- Existing grade determination by code official
 - Existing grade is the grade established in the 2021 survey submitted with the building permit application - OR - the interpolated grade done by neighbors based on the conclusions of the out of date administrative interpretation:

- Existing rockery needs mitigation
 - Michele's original email in October:
 - Comment:
The geotechnical engineering report indicates "...due to the loose nature of the upper fill soils behind the rockery, it would only be considered moderately stable, and likely has a current factor of safety of 1.0 or slightly higher with regards to slope stability."

PERMANENT SHORING PLAN

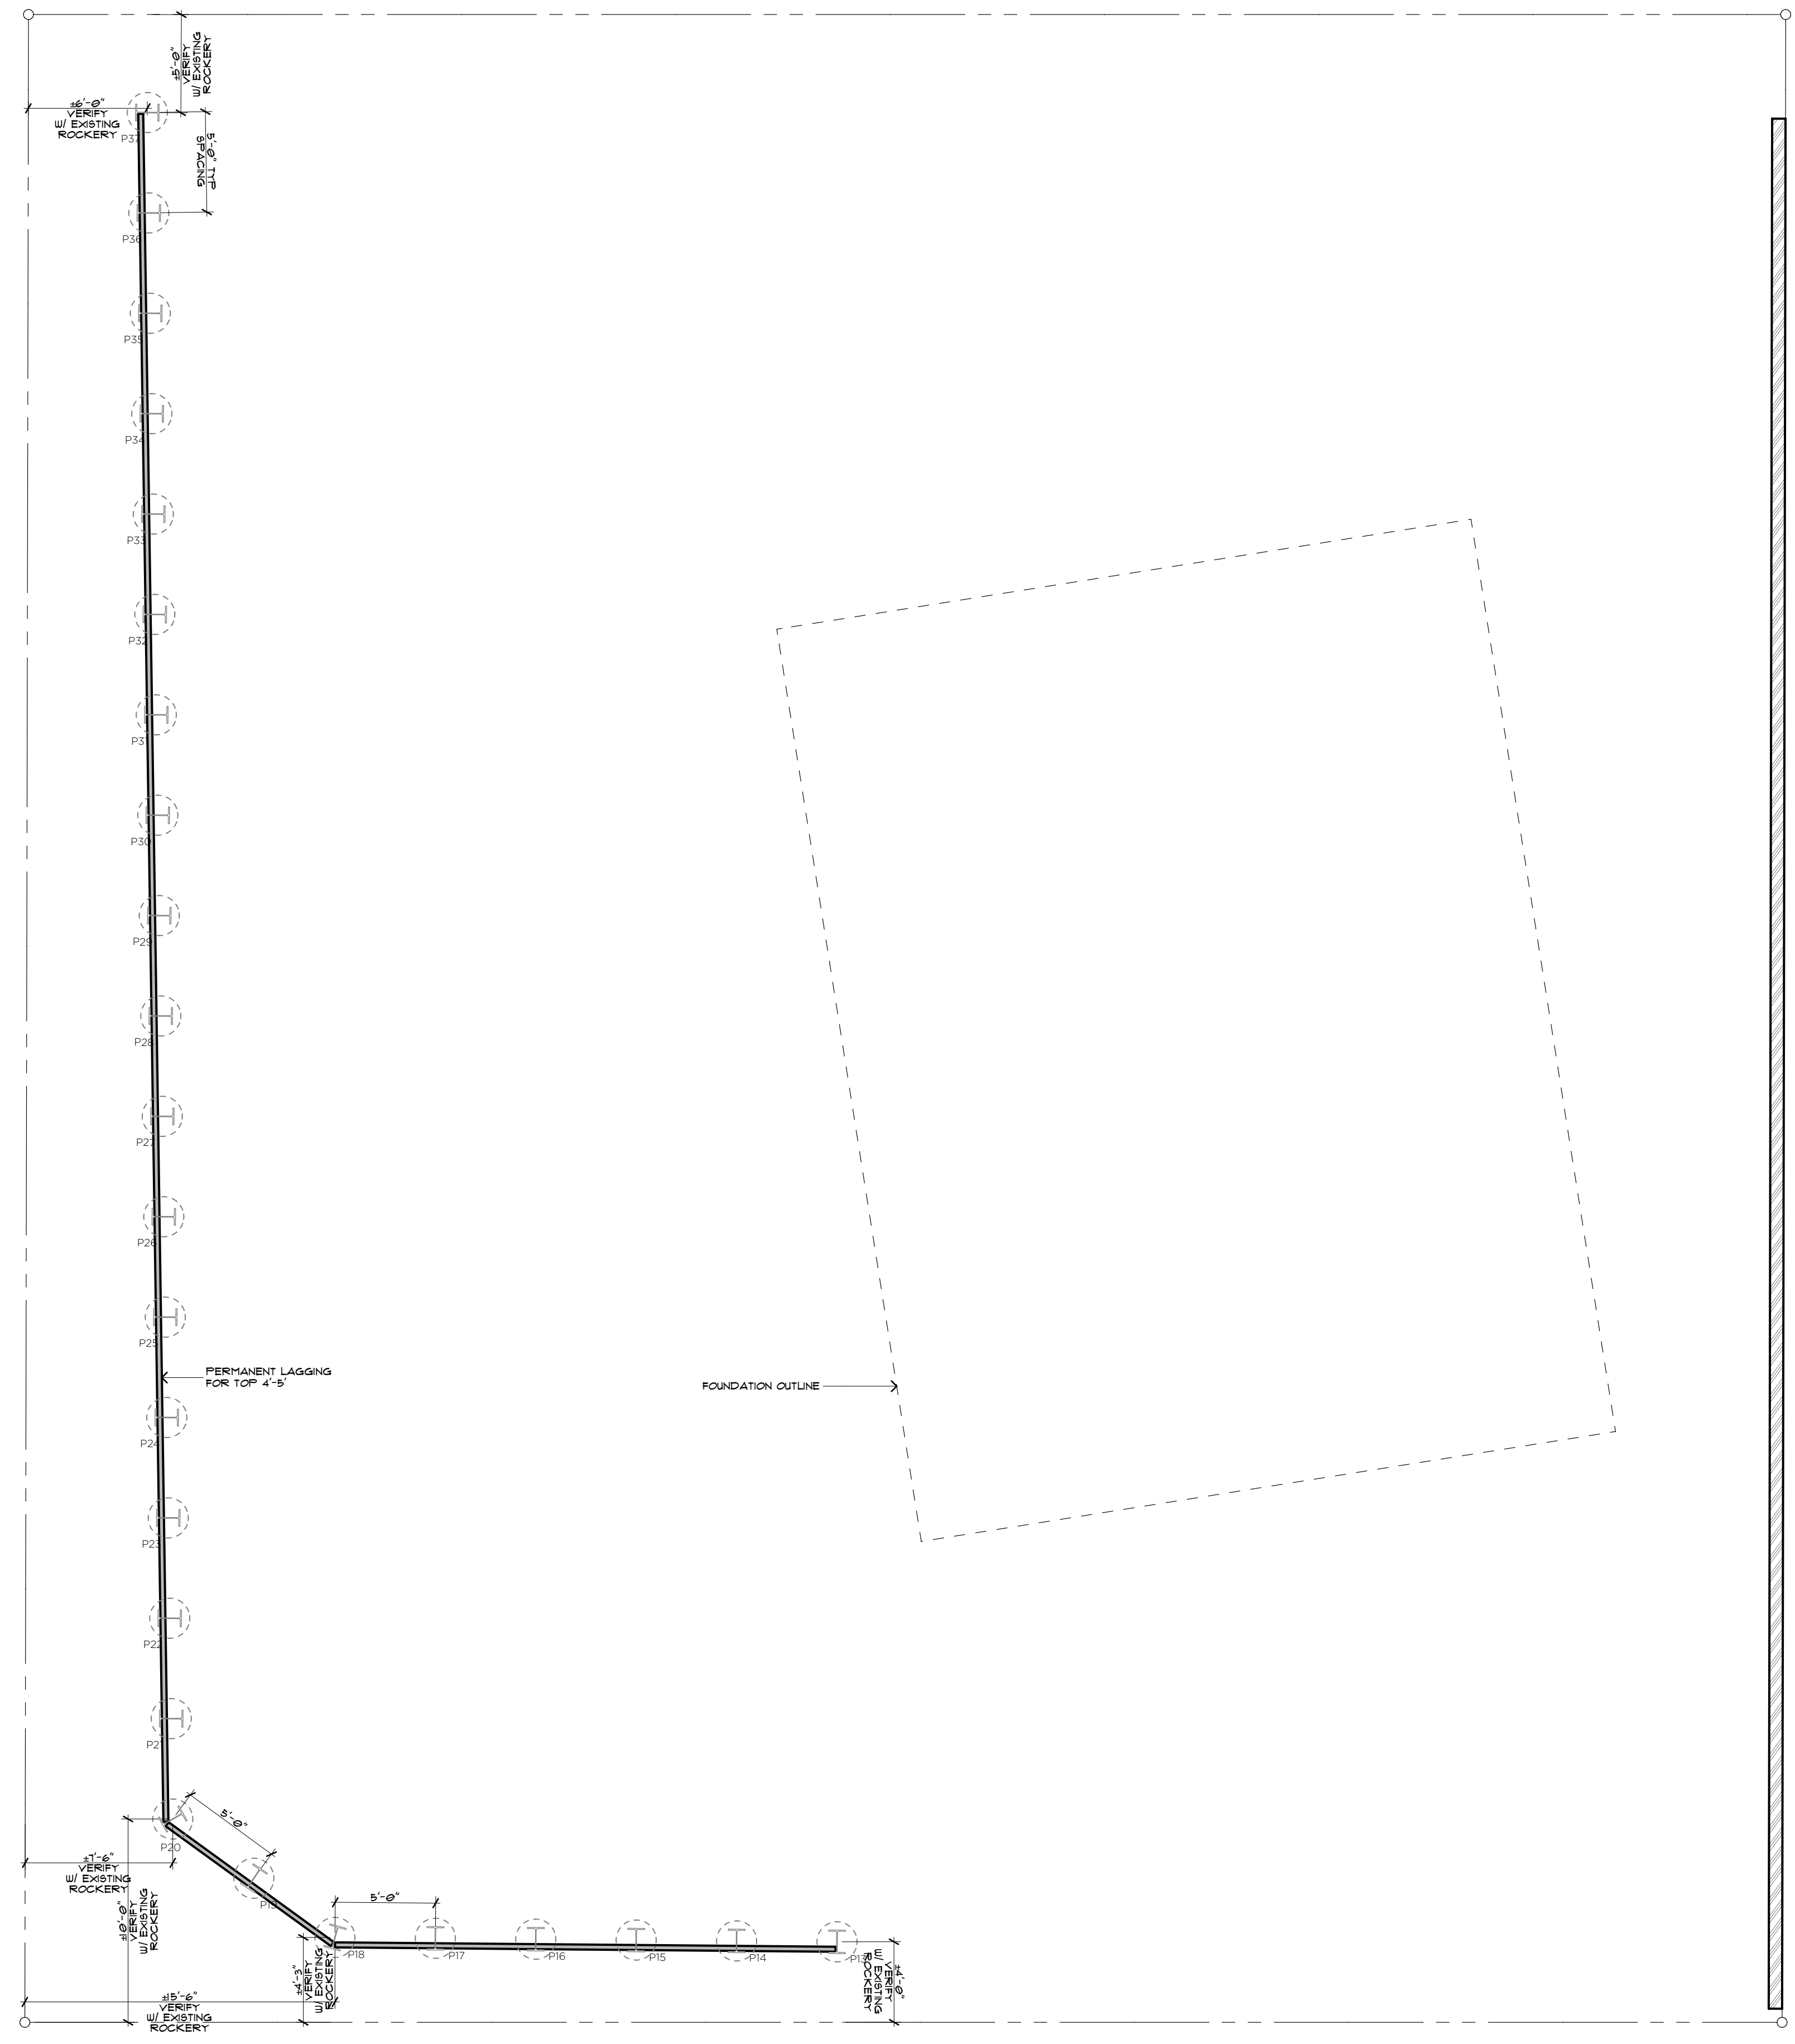
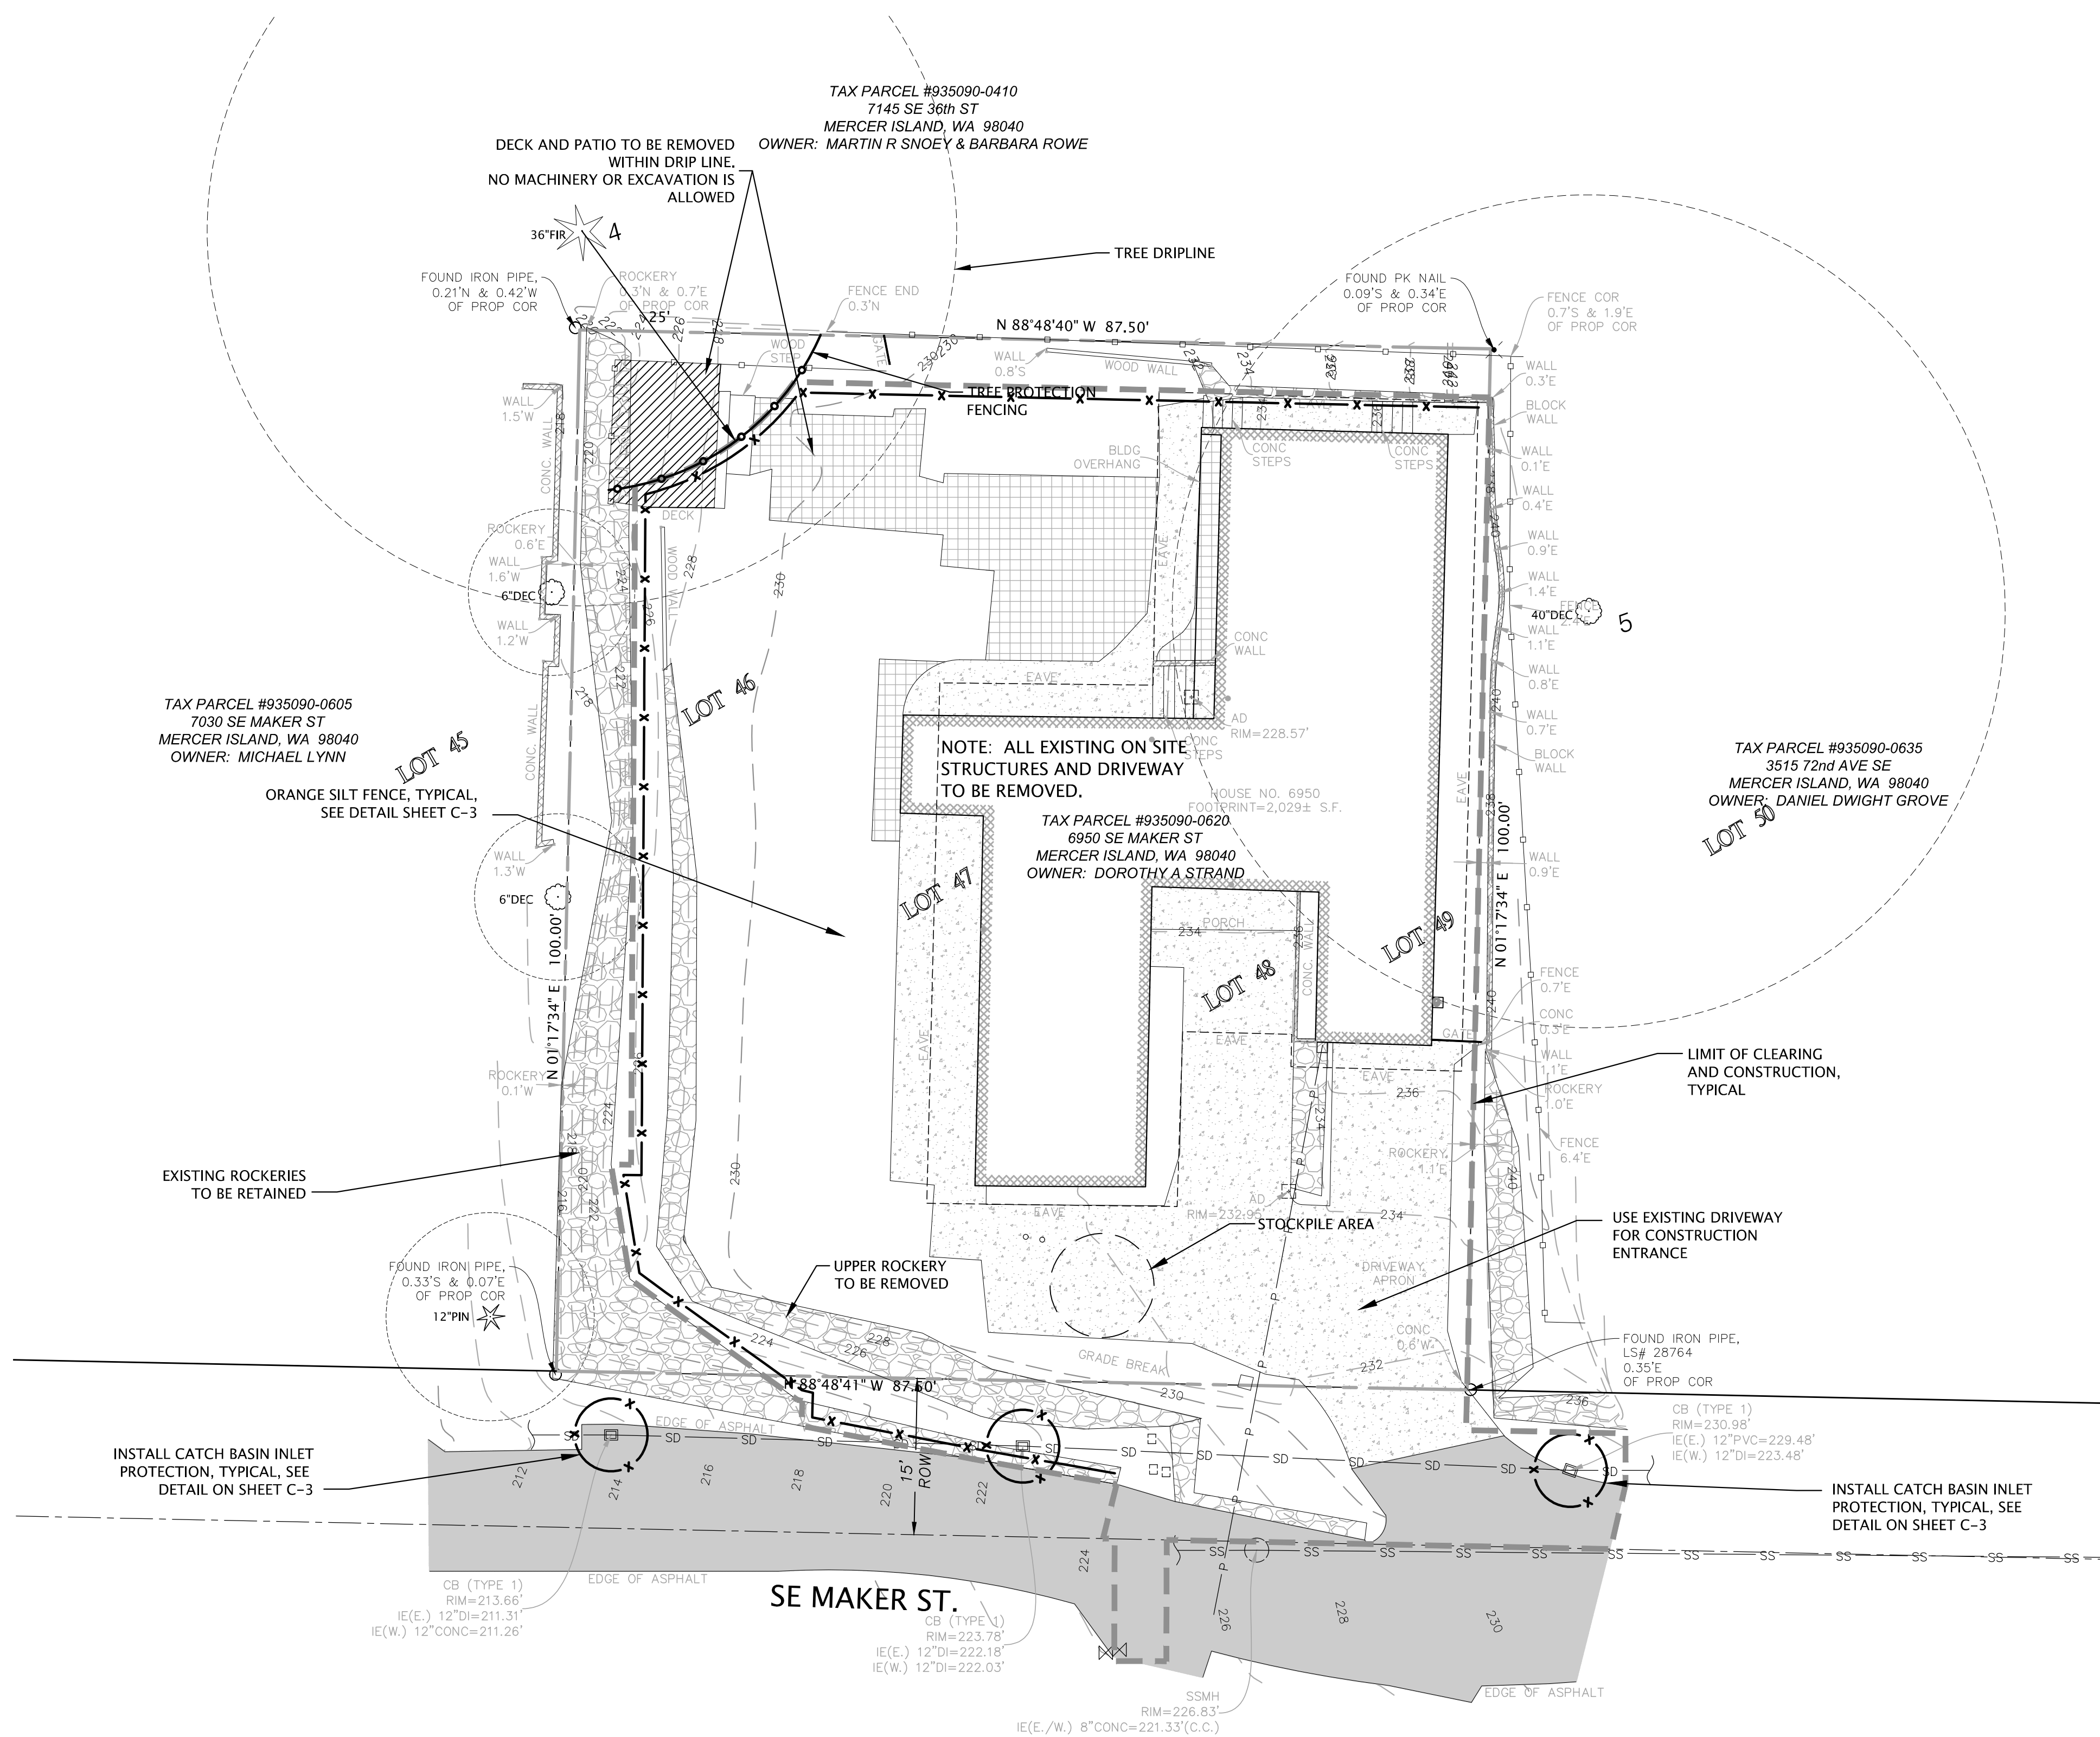
Indicate how this hazard is being mitigated (MICC 19.07.160).

Although the new site development is not "touching—altering" the existing rockeries (except for utilities that may be incorrectly located on the civil drawings) does this statement in the report identify a hazard that then has to be mitigated? FS of 1.0 is not the standard for long term stability—not to mention the use of rockery to retain a loose fill.

- March - Michele asked about height restrictions for the rockery. The rockery is located partially in the front and side yard setbacks, and partially in the ROW. Per MICC 19.02.050, the rockery is limited to 72 in height. The existing rockery is around 11 ft at the tallest point in the SW corner of the property. Michele stated that the height requirement in the front yard will complicate their mitigation of the marginally stable rockery.

- We determined that mitigation would be required for the rockery due to the fact that it was not constructed with methods that would have been legal at the time with the marginal factor of safety. Additionally, several public comments were regarding the rockery.

Michelle, please do not include the land use wall height requirement in your comment. Instead, please feel free to refer to Molly’s land use comment.

and maintenance of a legally nonconforming structure are permitted. In no event may any repair or maintenance result in the expansion of any existing nonconformity or the creation of any new nonconformity. However, Michele and Don's original comments stated that the rockery was not constructed using methods that would have been accepted for the factor of safety. Therefore, I don't think that we can use ordinary repairs and maintenance for the structure to maintain the existing nonconforming height.
